Re: Proposed S75W Modification to MP10_0166 Royal Prince Alfred Hospital North West Precinct redevelopment

The amendments proposed and the reason for these is described below and shown on Drawings DoP-100 and DoP-200 to 202.

DoP - ELEVATION - NORTH
1 : 500

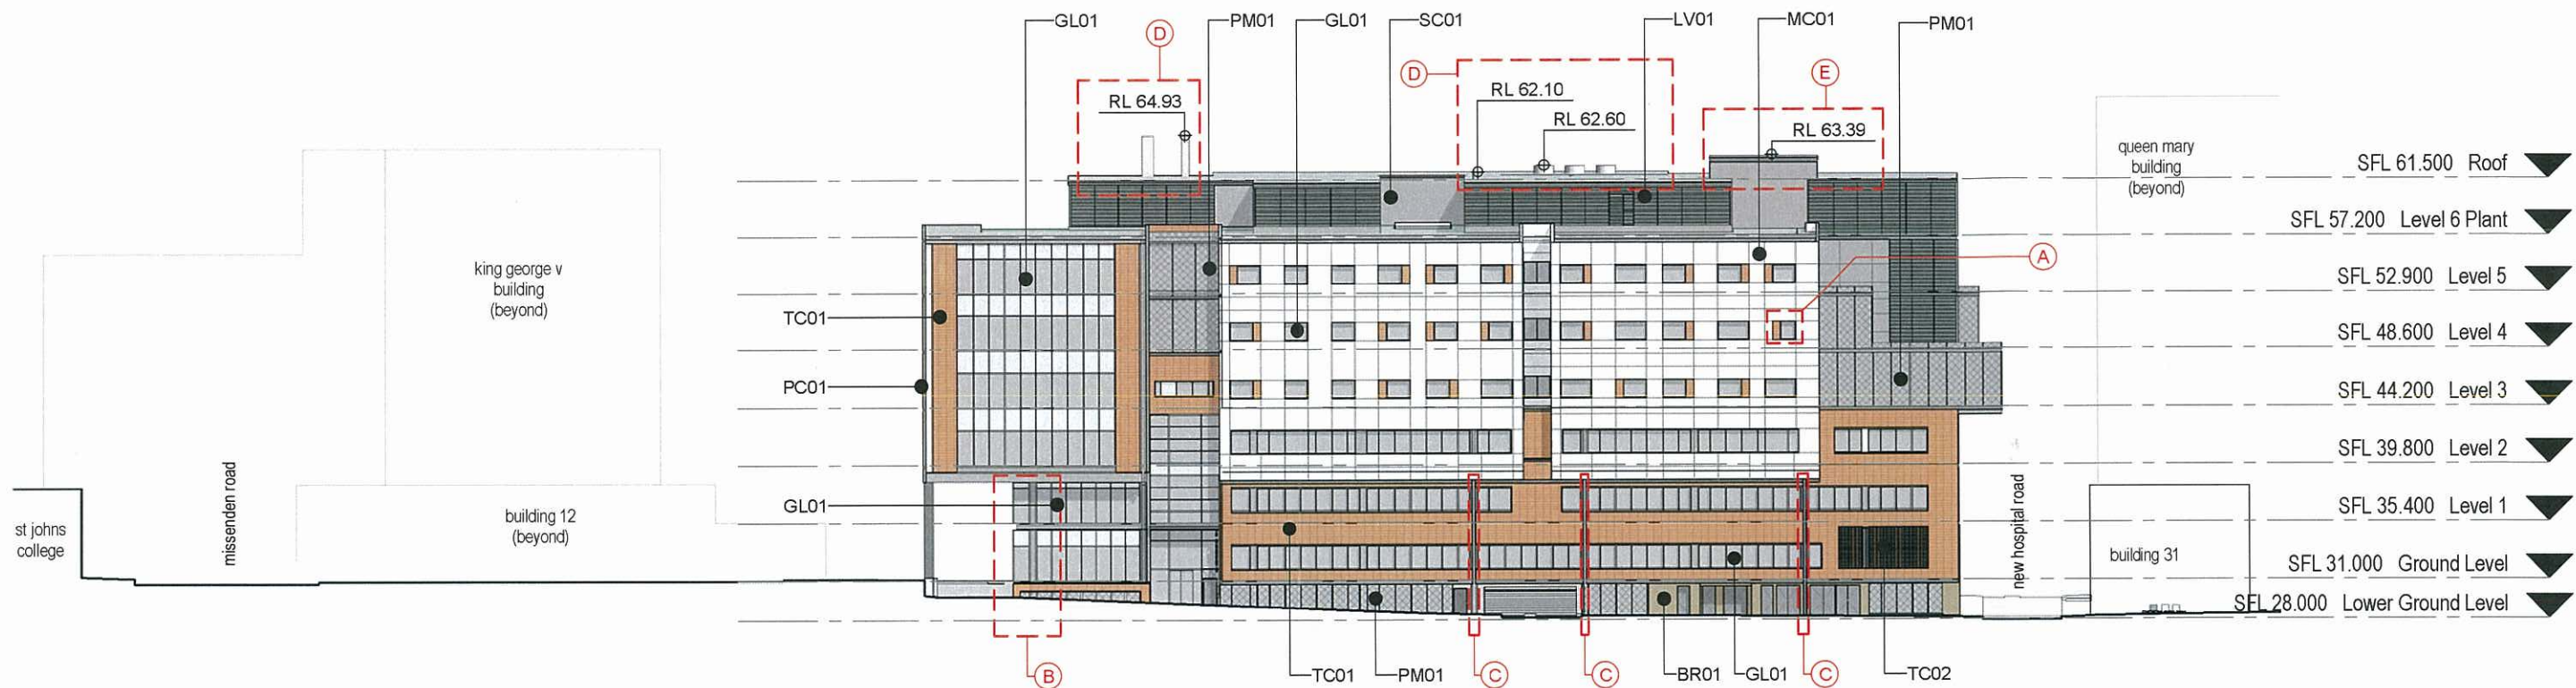
Amendment Reference	Amendment	Reason for Amendment
A.	Revised opening sizes and extent of glazing/terracotta cladding to openings	<p>The extent of openings have been further coordinated with the internal planning of the mental health unit layout to:</p> <ul style="list-style-type: none"> - optimise window locations with consideration to bedroom partitions, furniture and joinery layouts; - standardise window sizes; and - align the opening size within the courtyard at Level 4 (north) with the other openings on that level.

B.	Revised extent and configuration of curtain façade glazing to allow for vehicle turning	The extent and configuration of the curtain façade glazing has been revised to the staff/meeting area adjacent the vehicle entry forecourt following further review and coordination of vehicle swept paths into the forecourt.
C.	Locations of visible stainless steel downpipes	Further detailed design development and co-ordination to accommodate hydraulic services design and required downpipe locations.
D.	Locations and extents of mechanical exhaust flues	Further detailed design development and co-ordination to accommodate mechanical exhaust requirements.
E.	Increased height of lift overrun	Further detailed design development and co-ordination following advice from specialist lift manufacturer.
